Yarnton DAS Addendum - Schedule of changes
December 2023

Schedule - The following schedule aims to underline the necessary changes within the previously submitted DAS (June 2023).

FIGURE 25 - PLACEMAKING PLAN

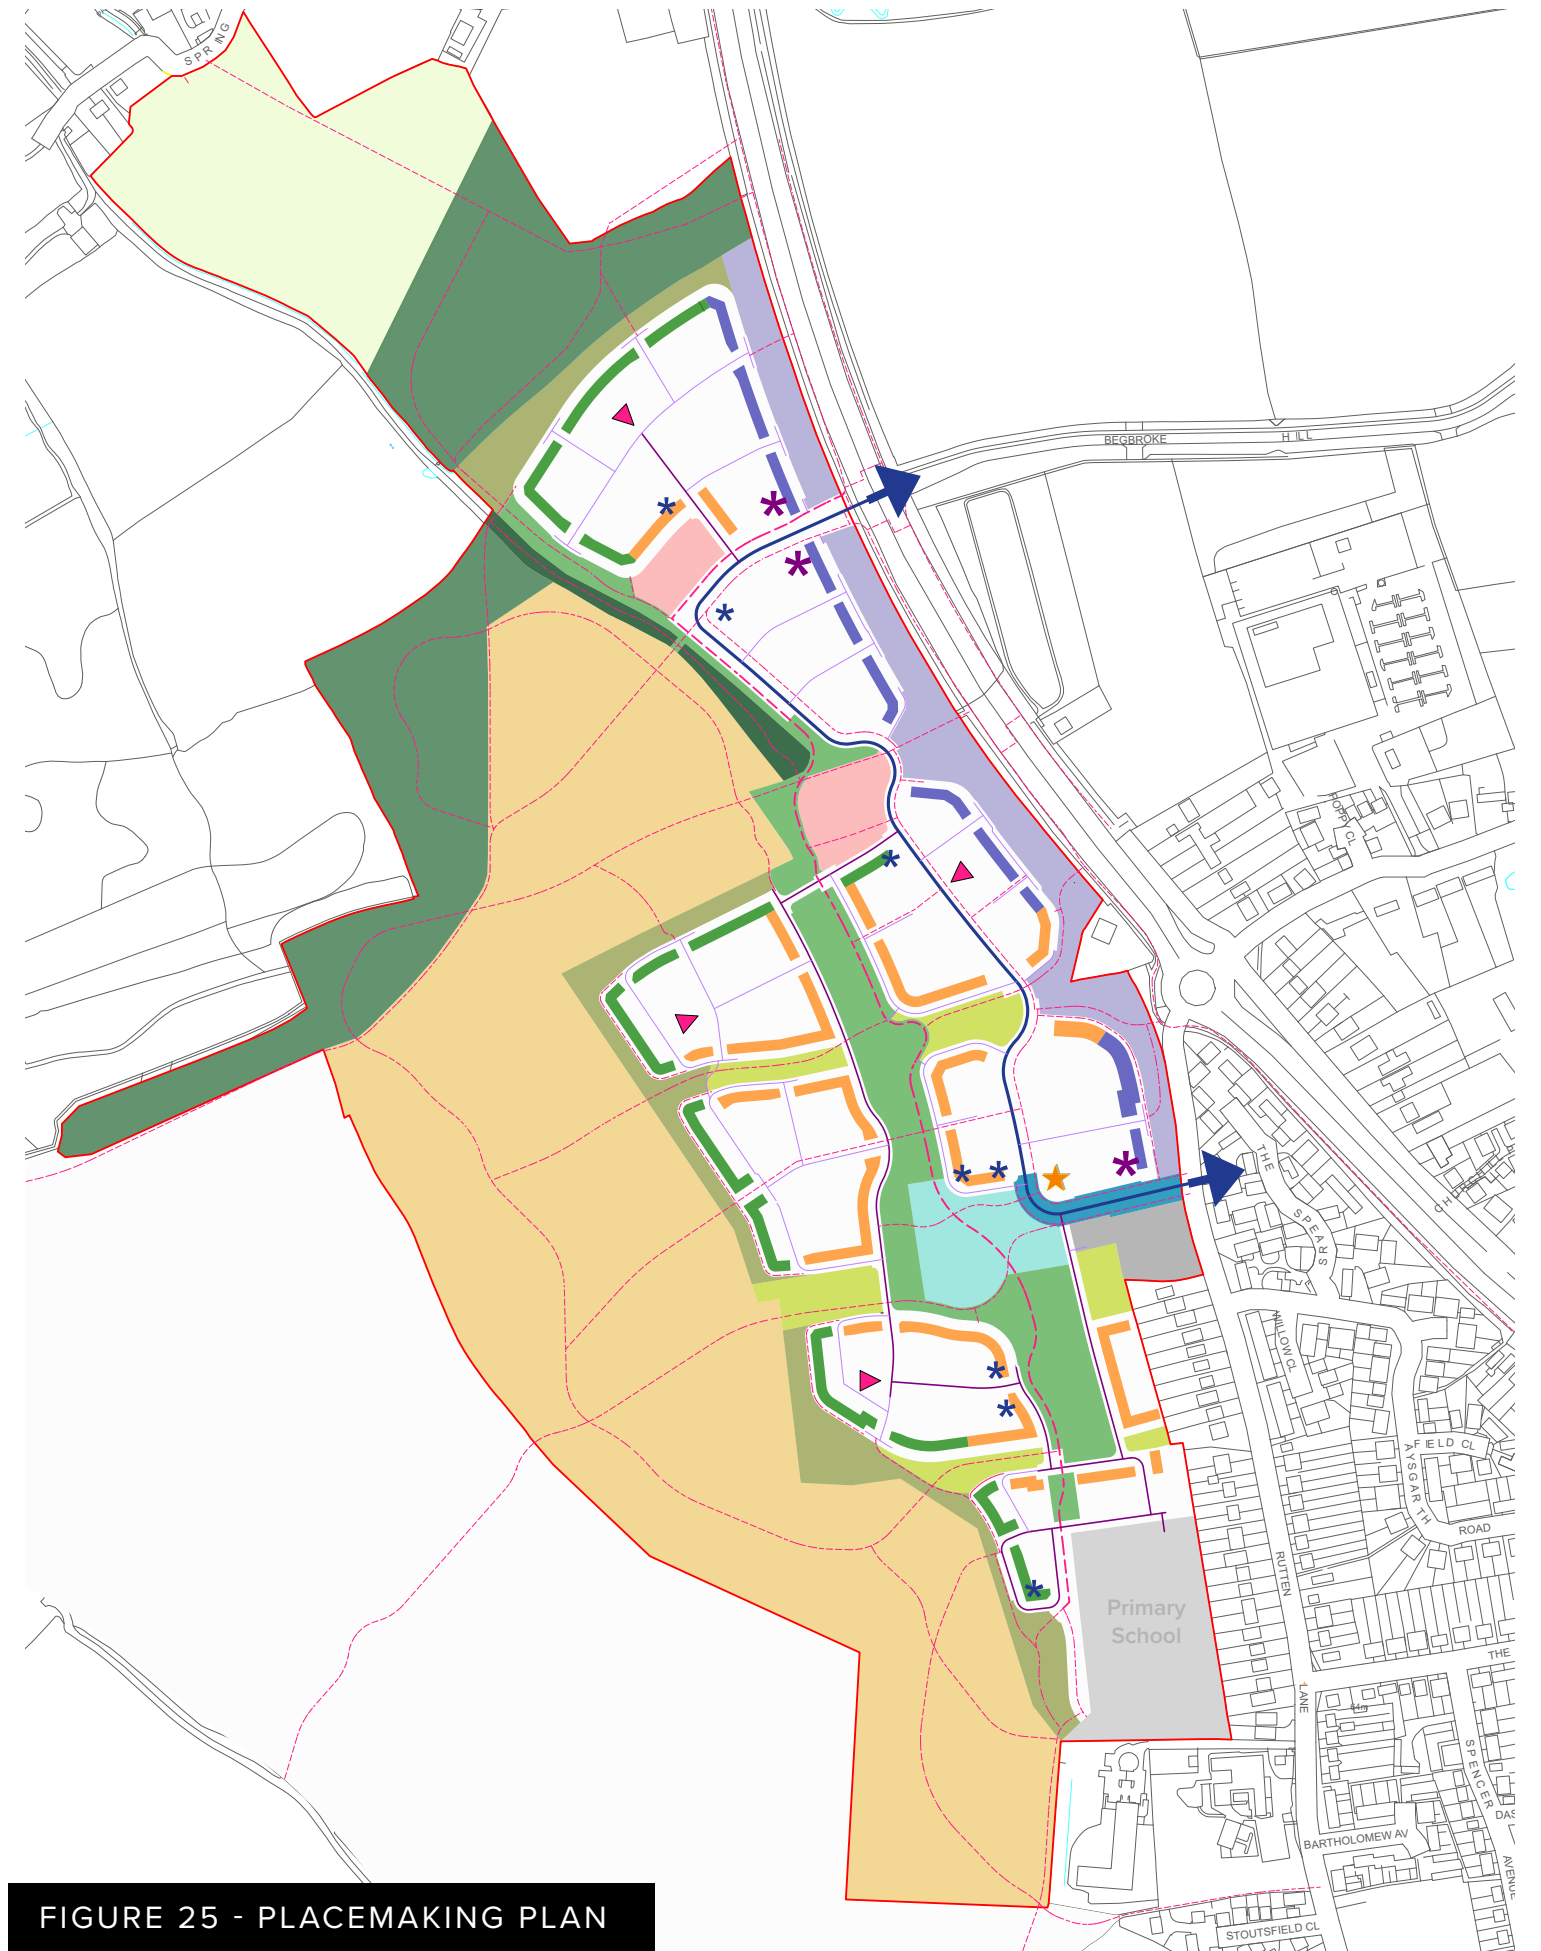
53	25	Placemaking Plan	- Plan to be updated to reflect changes to informal parkland, retained agricultural land and woodland
70	40	Key Spaces Plan	- Plan to be updated to reflect changes to informal parkland, retained agricultural land and woodland - Change key to 'Informal Parkland' instead of 'the Meadows'
88	-	Key Plan	- Change title to 'Informal Parkland' instead of 'the Meadowland' - Change text accordingly - Update Key Plan in line with Figure 40 (Page 70)
89	49	The Meadowland Illustrative Section / Plan	- Change title to 'Informal Parkland' instead of 'Meadowland'
90	-	Key Plan	- Update Key Plan in line with Figure 40 (Page 70)
91	50	Community Woodland Illustrative Section / Plan	- Plan to be updated to reflect changes to informal parkland and woodland to the northeastern corner in line with Figure 10 (Page 33)
140	-	Appendix C Legacy & Stewardship	- Update Text and Figure to reflect updated Appendix
